Application for Removal or Variation of a Condition following Grant of Planning Permission or
Listed Building Consent

Erection of a detached timber framed double garage.

23/502342/FULL

Drawing number: P 03	23011	Rev.
SUBMISSION B

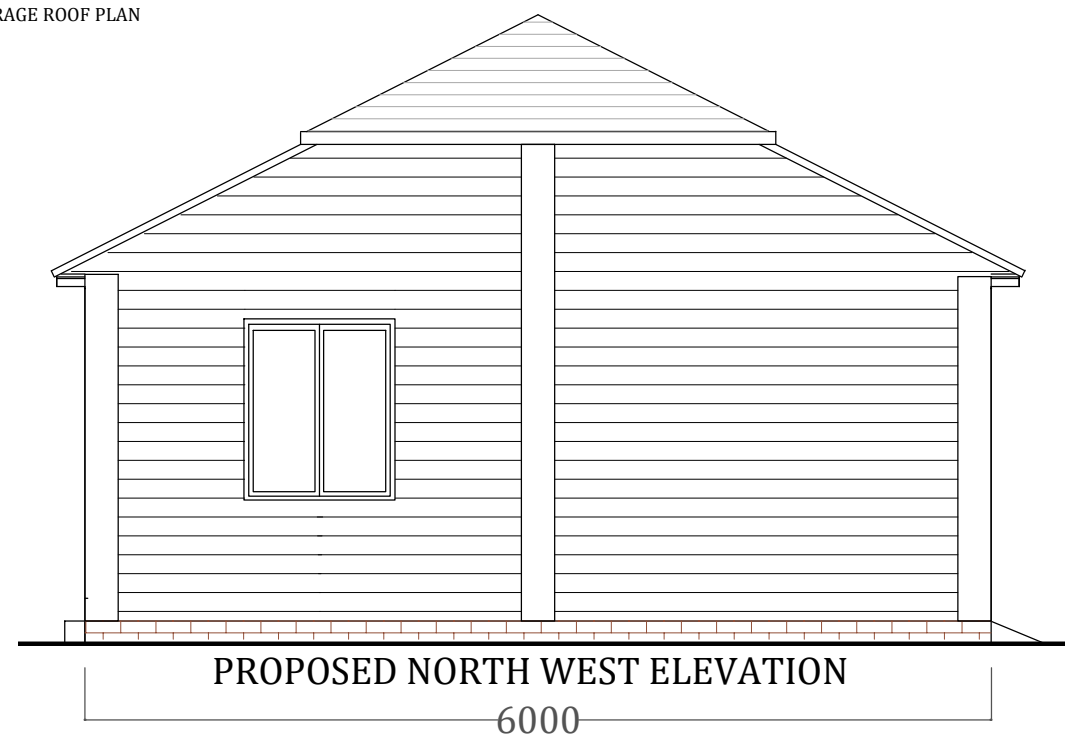
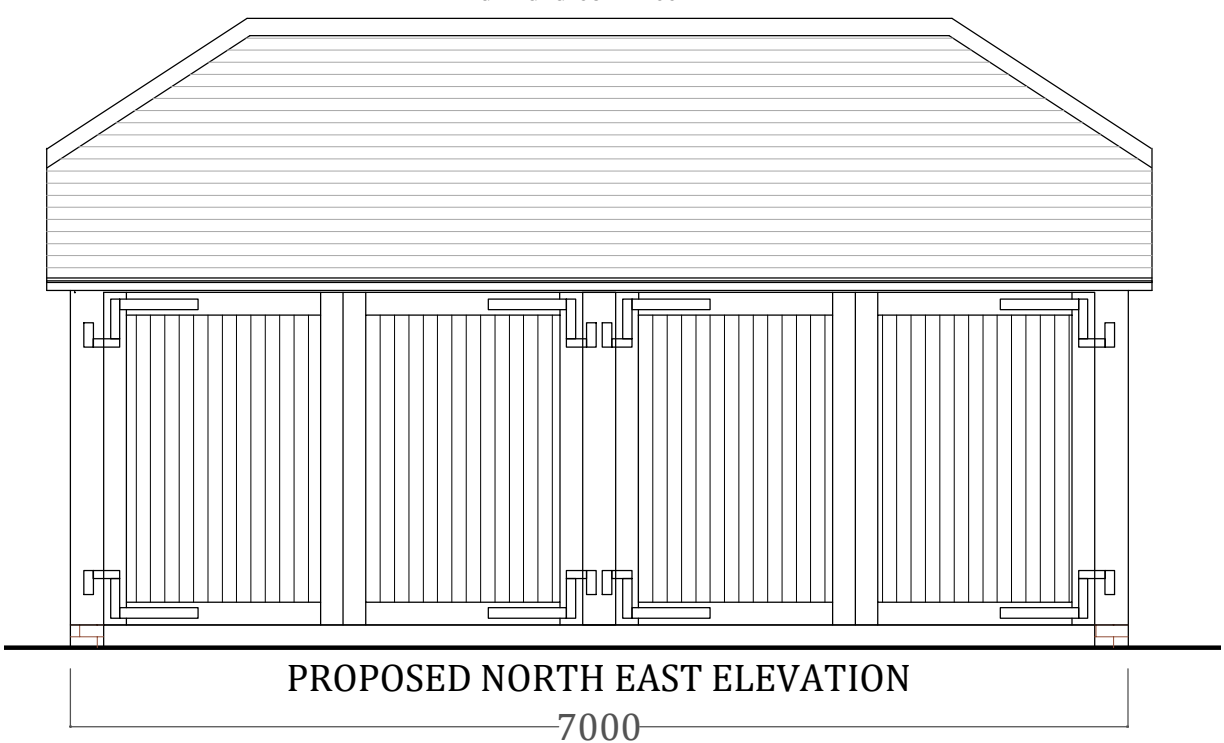
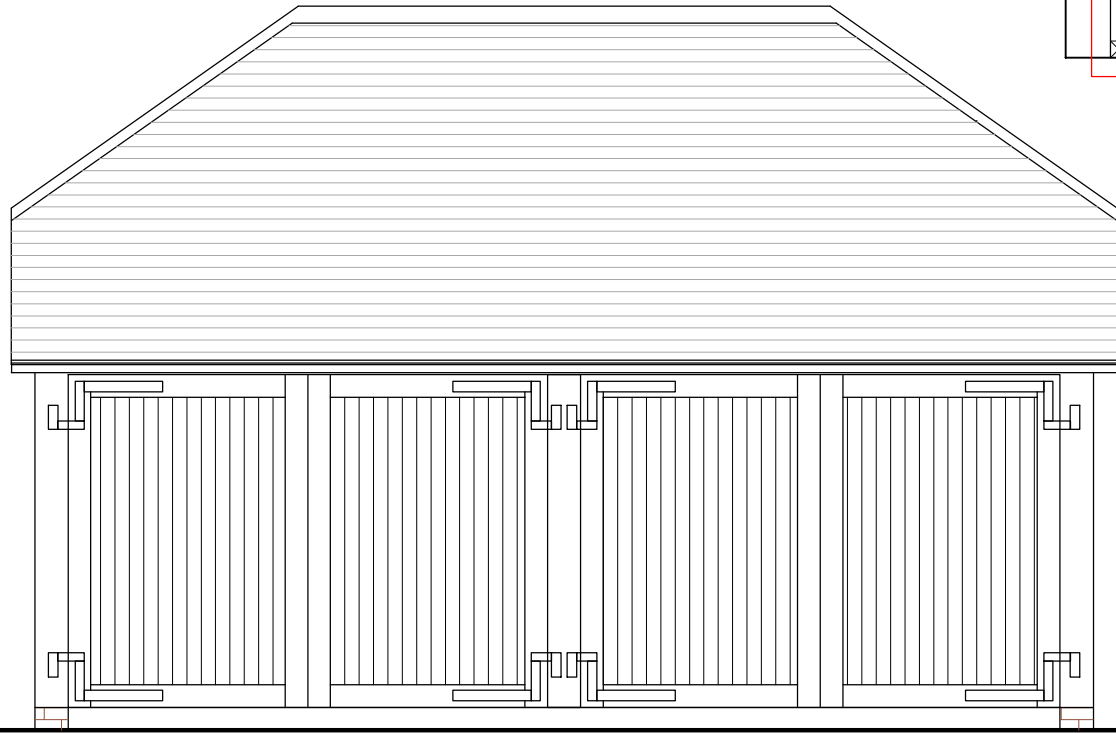
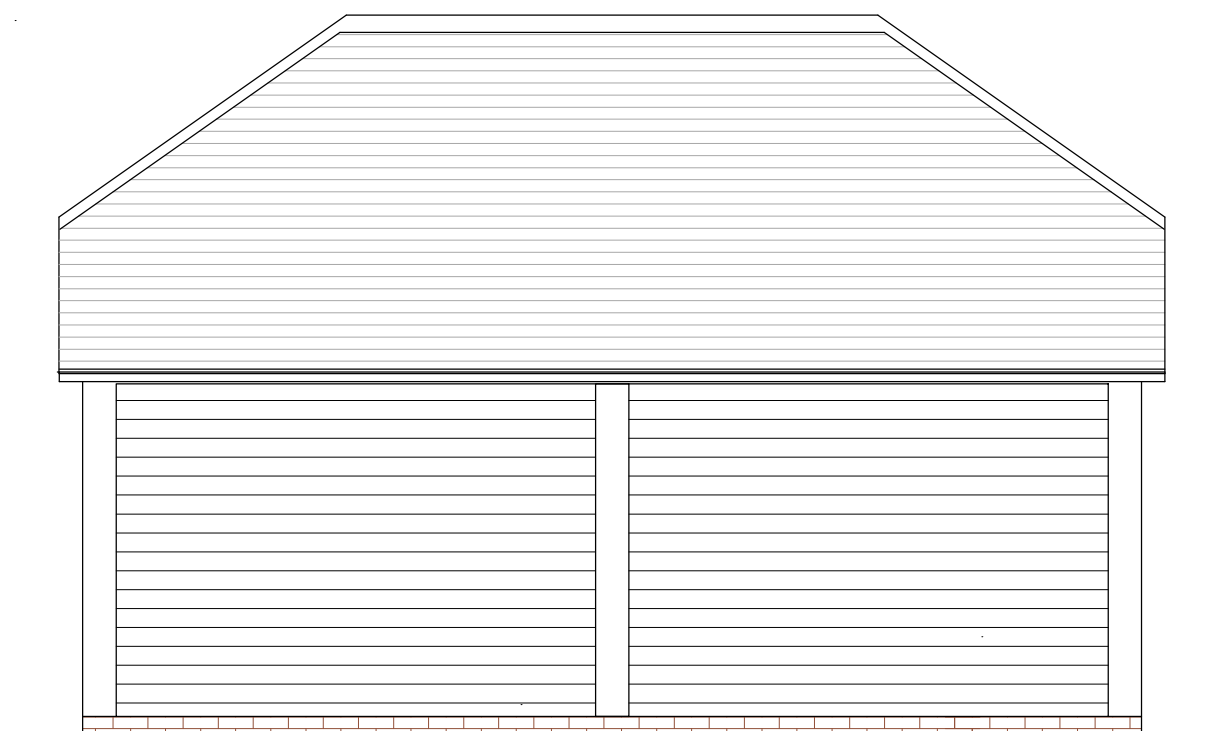
To change the existing pitch indicated on drawings P01 of the roof which is 28 deg to 35 deg indicated on drawings P03 so that the tiles will match the existing on the roof as stated in the original application.

To revise the elevations showing the new pitch of 35deg, tiles to match existing on the house
